Project Name: Jefferson Office Plaza

DRB Comments

RE: Lot 2-A-2, Jefferson Office Plaza

PLAT
 OF
LOT 2-A-2-A
JEFFERSON OFFICE PLAZA
 BEING A REPLAT OF LOT 2-A-2
JEFFERSON OFFICE PLAZA
 SECTION 35, TOWNSHIP 11 NORTH, RANGE 3 EAST, N.M.P.M.
 CITY OF ALBUQUERQUE, BERNALILLO COUNTY, NEW MEXICO
 SEPTEMBER 2008

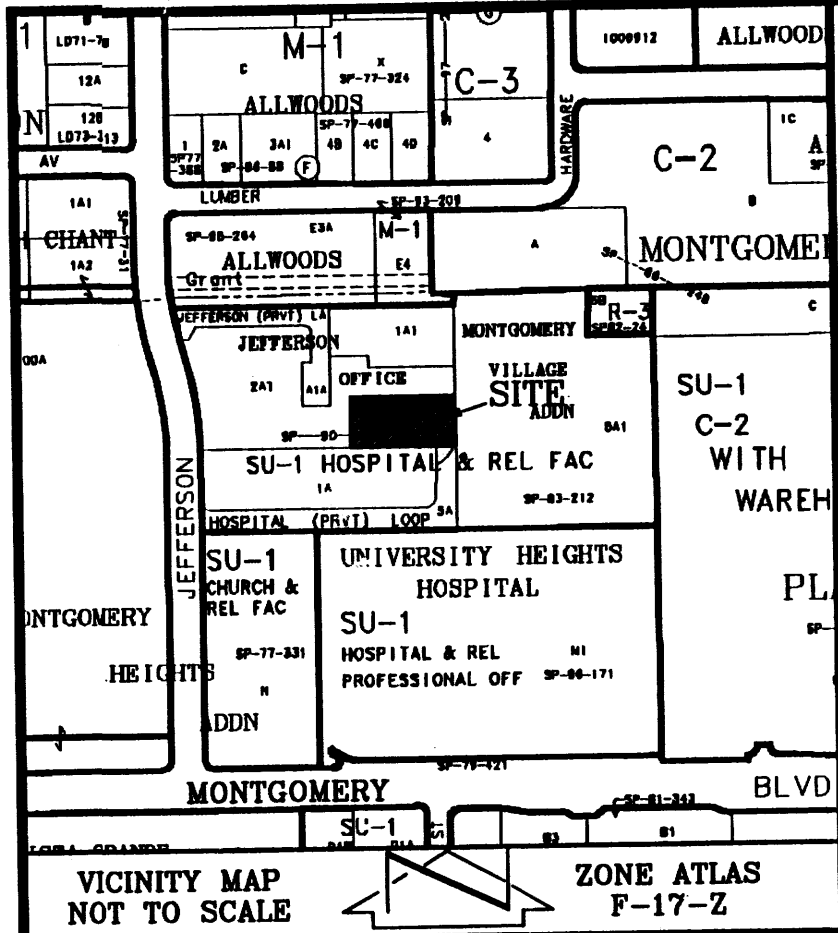
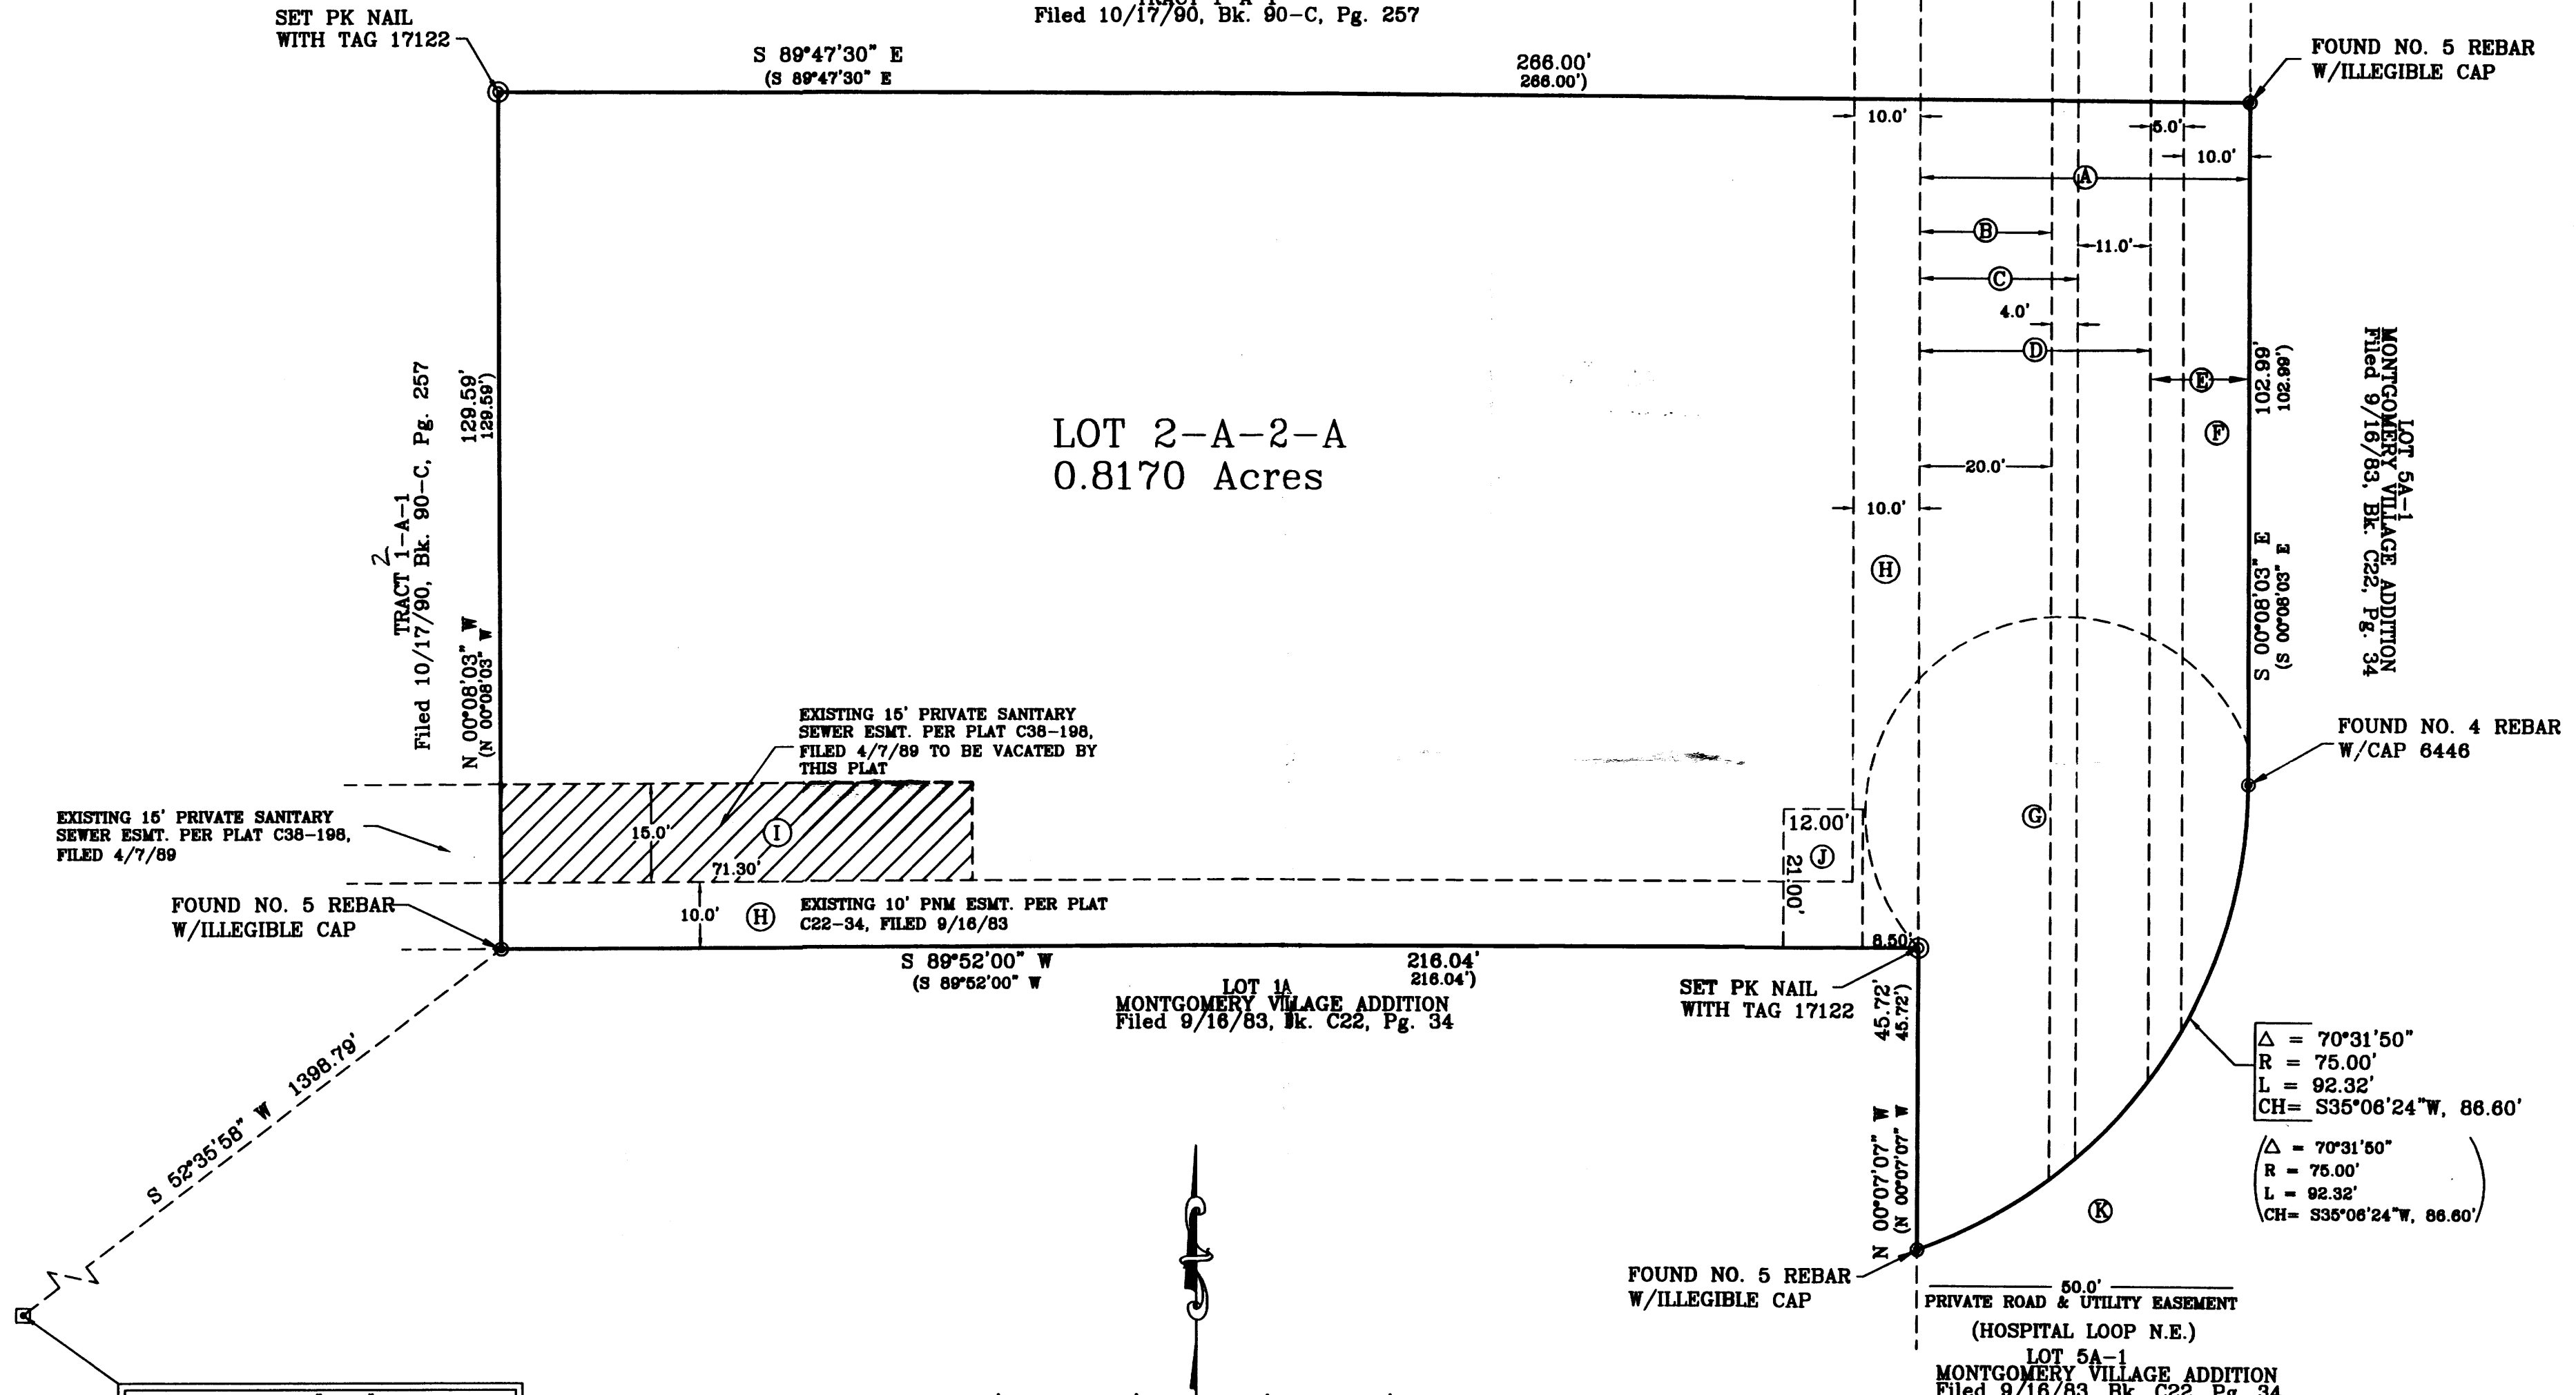
A separate application is required for Vacation of an easement.

The subject easement proposed for vacation is only 10 feet wide on this lot (reduced from 15 feet on the lot to the west, which should be noted as Lot 2-A-1 as the adjoiner on the west and north).

Additionally, there is a discrepancy in recording dates for Easements B, D and E.
